**THE ABLE MARINE ENERGY PARK DEVELOPMENT CONSENT ORDER 2014 (SI 2014/2935)**  
**('THE DCO')**

**APPLICATION FOR A NON-MATERIAL CHANGE TO THE DCO**

**RESPONSE TO REPRESENTATIONS**

Title: Indicative Landscape Masterplan

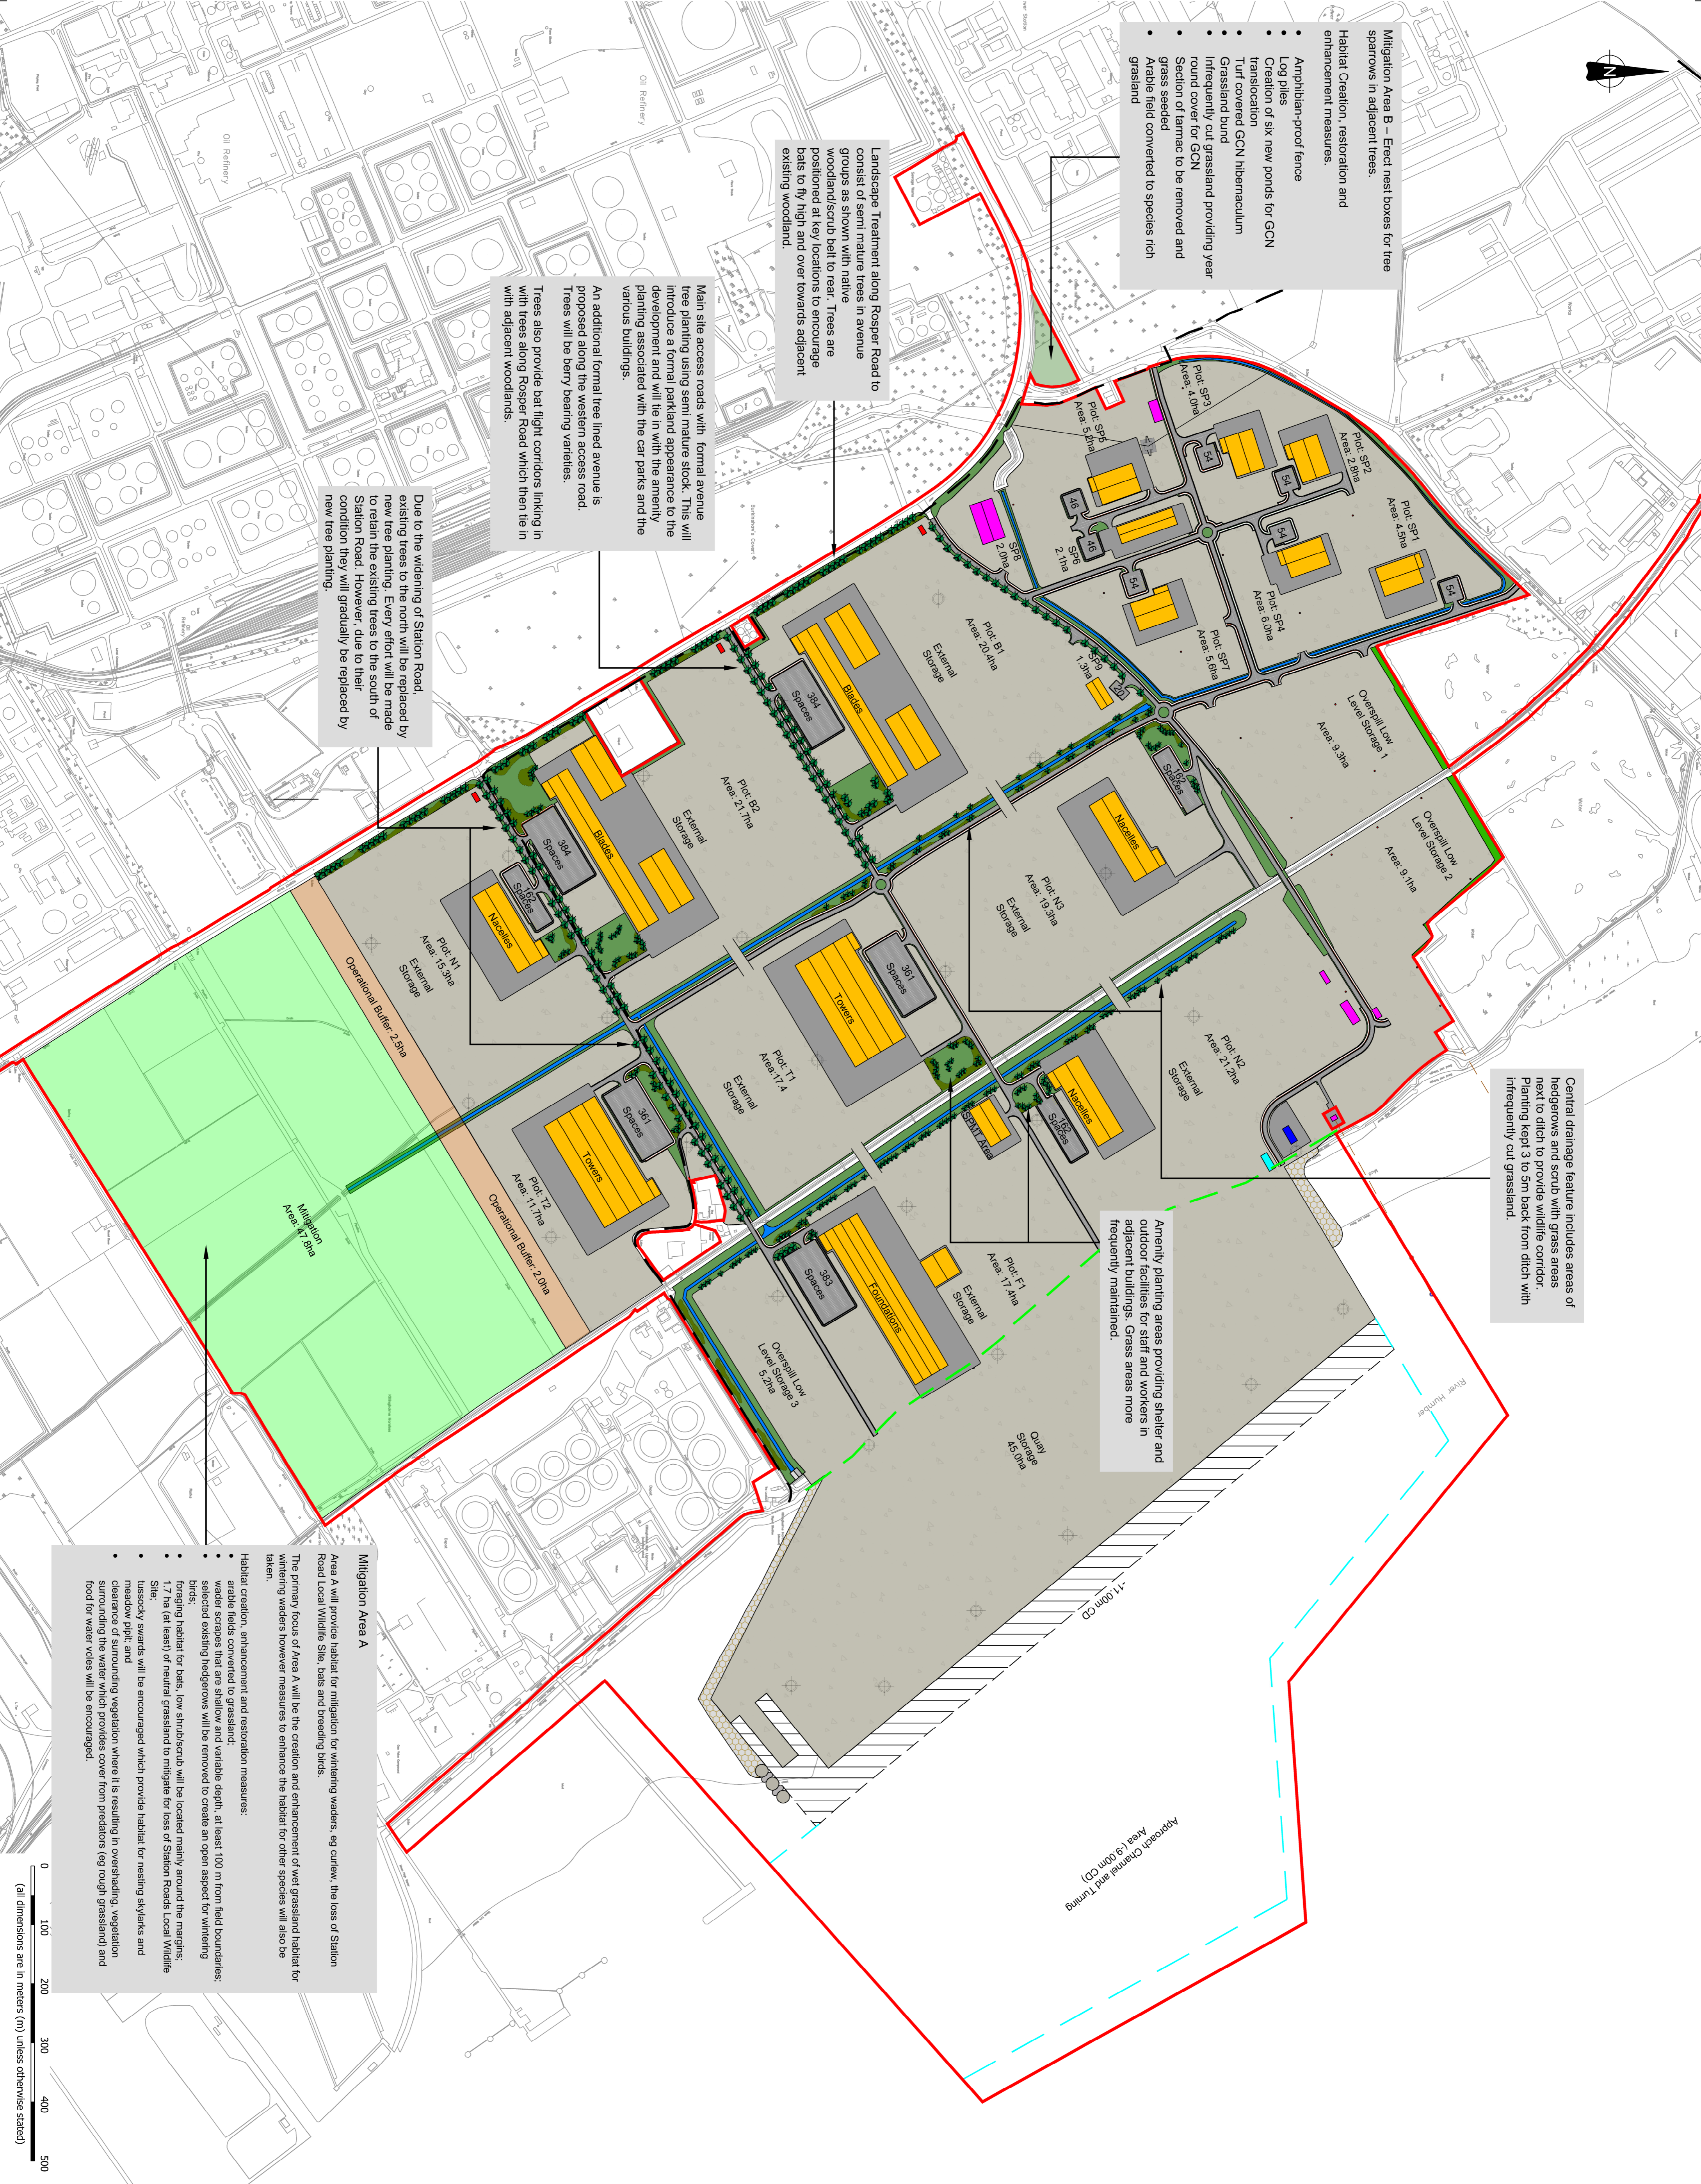
<p>The Applicant has considered the wrong scheme when assessing whether the scheme is EIA development.</p>	<p>Section 3.4 includes an assessment of the proposed change.</p>
<p>The Applicant's assessment is insufficient to allow it to conclude that the changes will not result in any significant adverse effects on the environment.</p> <p>The applicant must request a screening opinion from the Secretary of State in respect of the proposed change to establish whether environmental impact assessment is required in accordance with the EIA Regulations. In the absence of such a screening opinion, it must be the case that the Application cannot be considered to be a non-material change.</p>	<p>Able considers that the assessment it has undertaken is appropriate and proportionate to the change applied for and the conclusions are robust.</p>
<p>Our client is concerned that the applicant has actually failed to assess the material impact of the proposed location in accordance with the stated landscape mitigation objectives. In particular, the proposed relocation would result in the loss of a very large area of boundary planting that was specifically</p>	<p>Mitigation area A was to be developed to create open areas in the interest of roosting birds, not a screen. Accordingly, the proposals included hedge removal and tree clearance. The details of the proposals are set out in the Indicative Landscape</p>

identified as an important measure to break up the scale and mass of buildings and hardstand forming part of the AMEP and its consequential impact on the SRFLWS and surrounding landscape character areas.	<p>Masterplan which was submitted with the application for the DCO.</p> <p>The potential Landscape and Visual effects of the proposed change have been properly and fully, considered and the results set out in <b>Table 3.1</b> in the <b>Application Statement</b>. The re-siting of Mitigation Area A is not considered to give rise to any material change.</p>
---	--
